Ribble Valley Borough Council
Housing & Development Control

Application no: **3/2023/0056**

Address: **Phynis Farm Catlow Road Slaidburn BB7 3AQ**

Proposal: **Proposed conversion of former farm buildings to form four dwellings including the change of use of land to form private curtilage areas and the remodelling of the central courtyard.**

drawing title	Site Plan As Proposed
scale @ A3	1:200
date	07.11.2022
dm	JT
chk'd	RR
drawing number	1541-009
sheet number	A

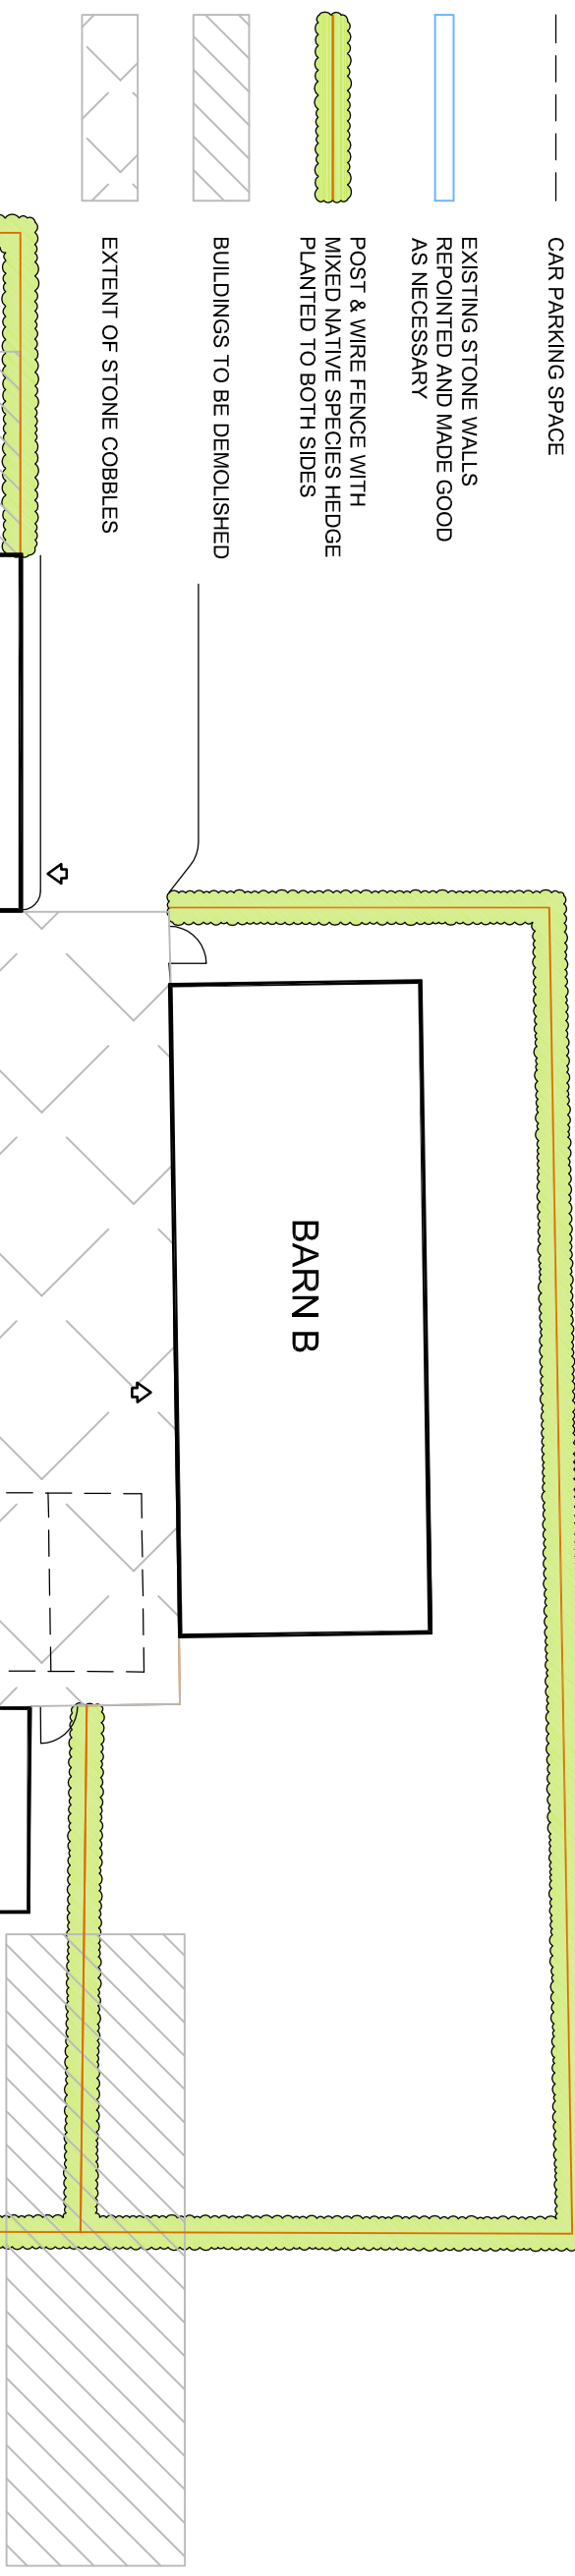
The LHA have reviewed Cass Associates drawing number 1541-009 Rev A titled "Site Plan As Proposed" and are aware that the parking arrangements complies with the LHAs parking guidance, given the number of bedrooms at each dwelling. Therefore, the LHA have no objection to the proposal.

5. The development hereby permitted shall not be occupied until such time as the parking and turning facilities have been implemented in accordance with Cass Associates drawing number 1541-009 Rev A. Thereafter the onsite parking provision shall be so maintained in perpetuity.
